Recommendation Report for Planning Permission for Works or Extension to a Dwelling

REF NO: BN/88/20/HH

LOCATION: 55 Elm Grove
Barnham
PO22 0HJ

PROPOSAL: Single storey rear extension and provision of first floor accommodation over existing bungalow including demolition of existing conservatory and studio outbuilding and reduction of porch size.

GROUND FLOOR PLAN
SHOWING REPLACEMENT EXTENSION & ALTERATIONS

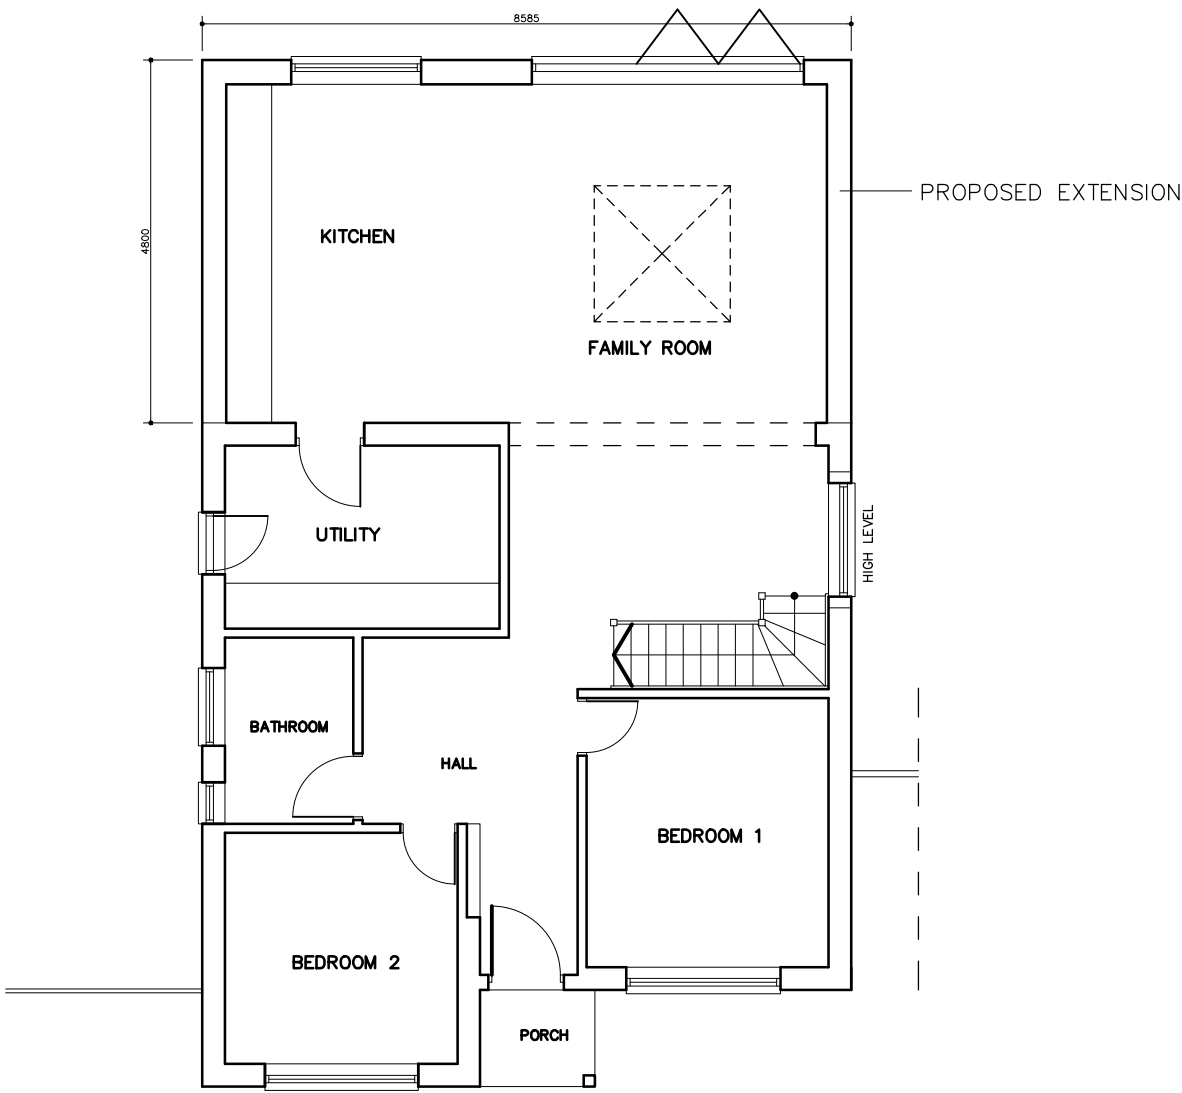
There is a conservatory to the rear which will be replaced with a single storey extension. The depth of this will increase by 1.5m to a total depth of 4.8m and a height of 2.6m, however this does not extend beyond the property to the north west. There is a side window to the extension at this property (No.54) however with doors to the rear and due to the separation between the properties with 1.9m retained to the south eastern boundary and 2.4m retained to the north west, it is not considered to result in an adverse overbearing or overshadowing impact. There is sufficient boundary treatment consisting of fencing and hedging.

There will be 1 additional high level window to the south east ground floor elevation and doors to the rear however the alterations at ground floor are not considered to result in views additional to that already achievable.

FOR MR & MRS BRIGDEN		
SITE 'WOODLANDS', 55 ELM GROVE, BARNHAM, WEST SUSSEX PO22 0HJ		
TITLE PROPOSED EXTENSION & ALTERATIONS PLANS & ELEVATION		
SCALE 1:100 © A2	DATE 07/20	DRAWING NO. 03 REV A

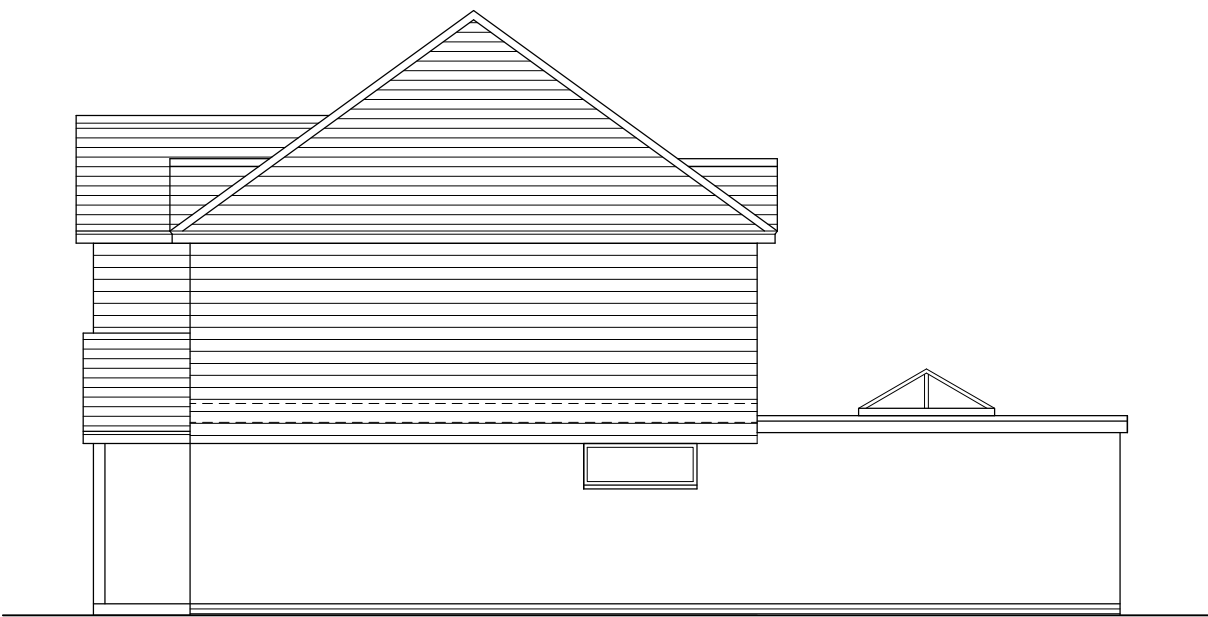
This will increase the height of the roof and as such is not considered a subservient addition. The alterations are however considered well integrated with a hipped roof.

The first floor will be clad, however there are examples of cladding nearby and in keeping with the locality. The colour is proposed as a light blue or green but currently undecided. As such a condition will be included in which details should be submitted to ensure it appears acceptable. The roof is also proposed to be slate. There area has predominantly red tile however the alteration is not considered to result in the dwelling appearing significantly out of character with the surrounding area. The roof tiles can also likely be changed under permitted development.

With the addition of a first floor, the dwelling will increase in height by approximately 2.5m.

Whilst the height will increase and the property is of a larger scale than the neighbouring properties, the two storey element does not extend beyond the building line of the neighbouring bungalows and due to the separation between them it is not considered to result in an adverse overbearing or overshadowing impact.

- 3 No development above damp proof course (DPC) level shall take place unless and until a schedule of materials and finishes to be used for the cladding to the first floor have been submitted to and approved by the Local Planning Authority and the materials so approved shall be used in the construction of the building.
